RE: **James Dwyer Substation Parking Lot Expansion**  
**12700 Montgomery NE**  
**Grading and Drainage Plan**  
**Engineer's Stamp Date: 2/1/19**  
**Hydrology File: G23D011**

Based on the submittal received on 2/4/19, the Grading Plan cannot be approved for Grading or Paving Permit until the following are corrected:

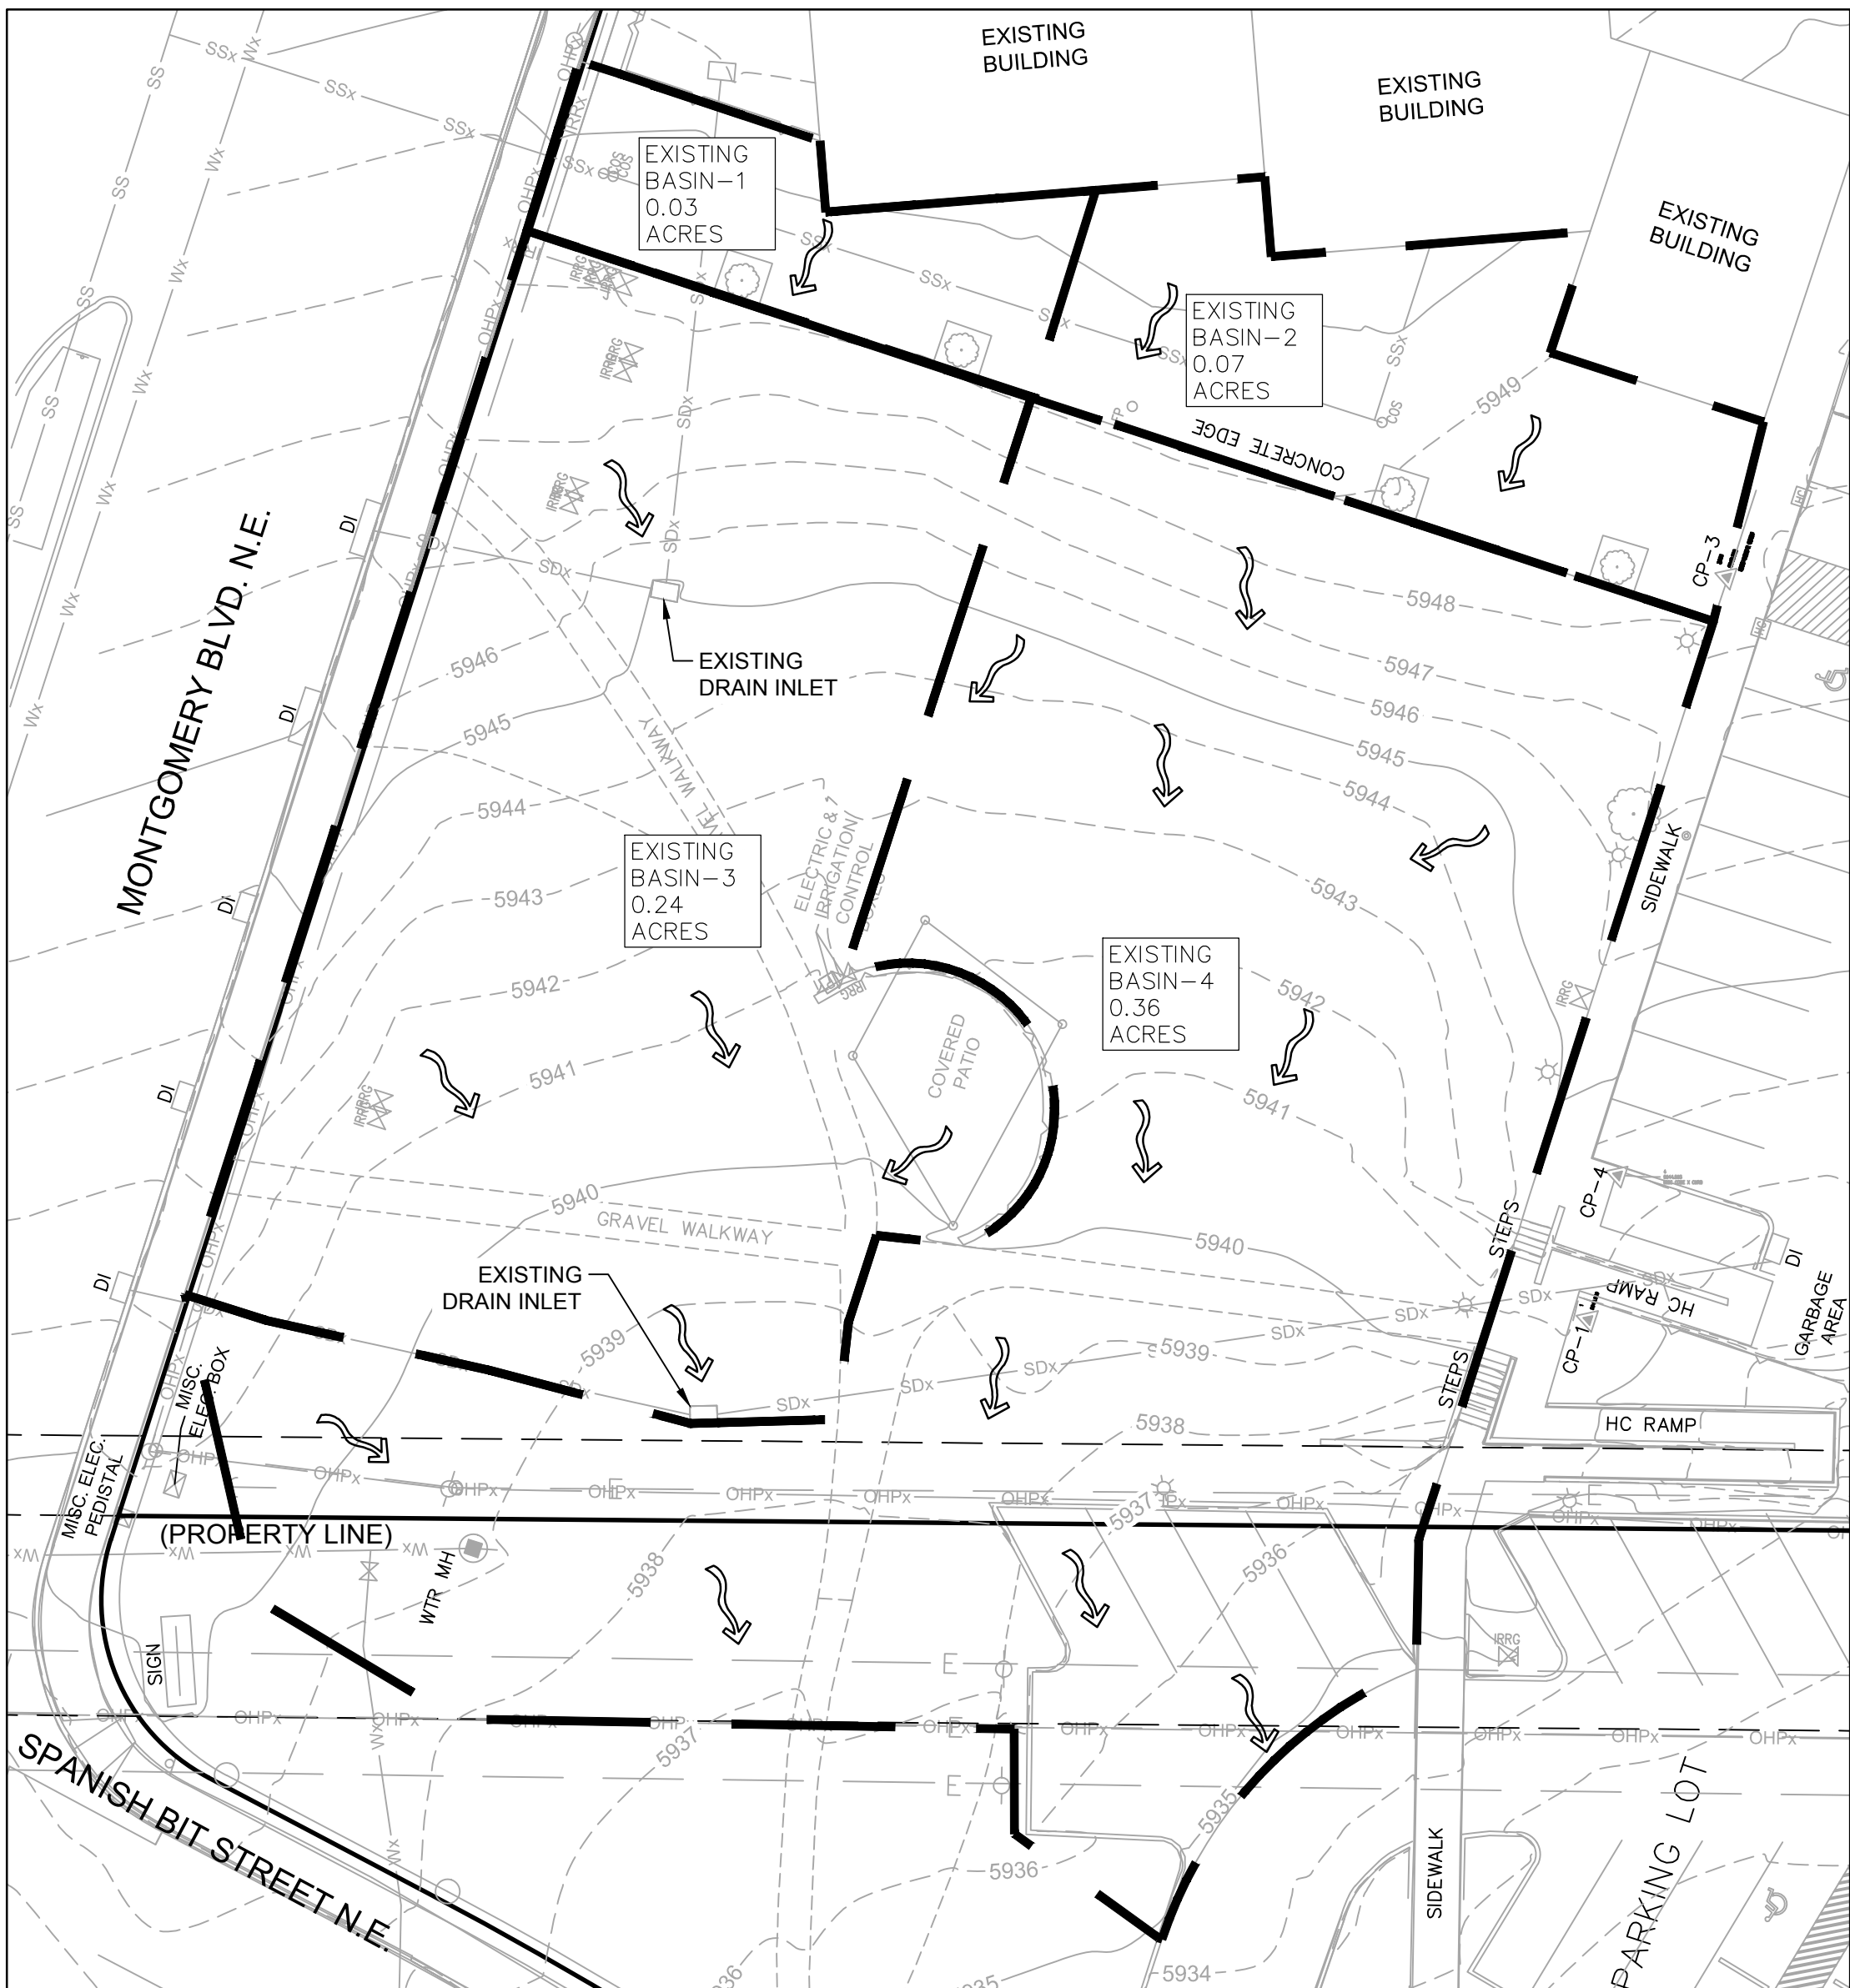
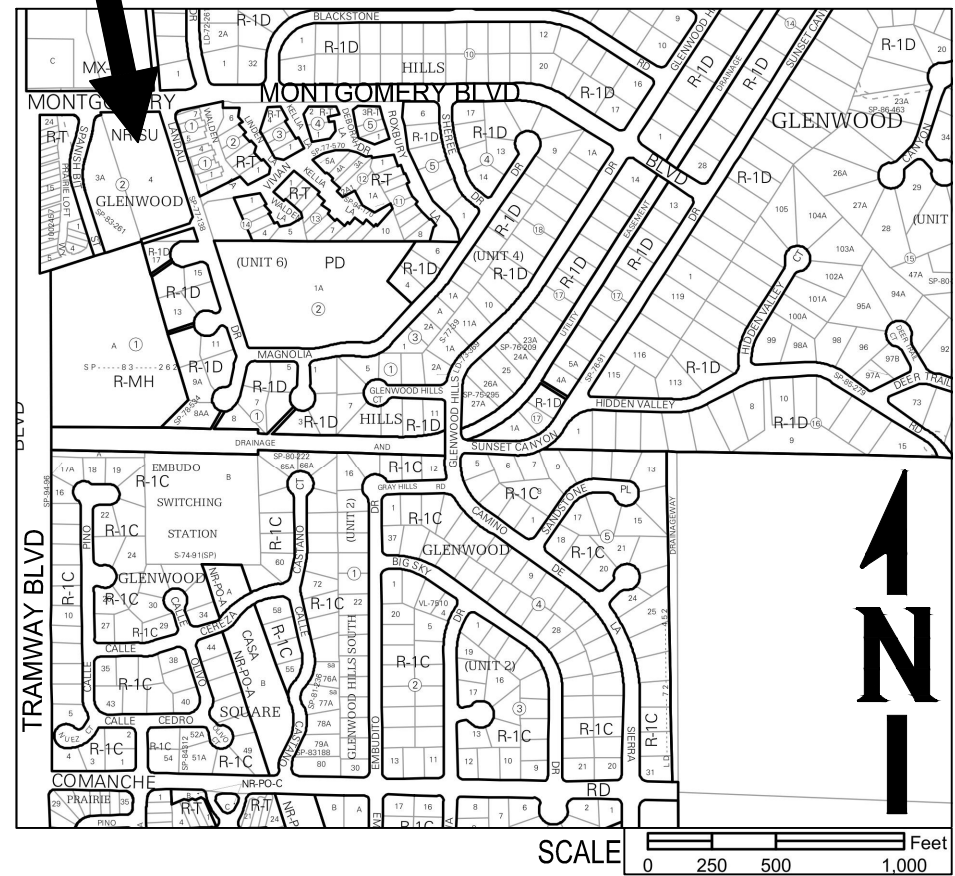
1. The pond needs to be sized for the undeveloped area between the pond and Montgomery, as this area drains into it also:

2. Because this pond serves as a detention pond, provide a primary outfall to the public ROW and include pond routing calculations and the storage-discharge curve. It'll also need an emergency spillway, sized for the 100-yr peak inflow. Alternatively, the pond can be converted to a retention pond if it is upsized to retain the 100-yr, 10-day volume. If configured this way, pond routing calculations and primary outfall are not required.

3. Provide an armored swale between the parking lot and back of sidewalk on Montgomery to convey flows to the pond.
4. Provide sections and hydraulic capacity calculations for the valley gutter/drive entrance. It seems as though peak flows will jump the valley gutter and continue out the drive entrance, bypassing the pond.
5. Provide additional spot elevations and grade-to-drain notes to ensure ponding does not occur at the SW corner of the parking lot. Also provide erosion protection between this corner and the adjacent stairs on the steep slope:
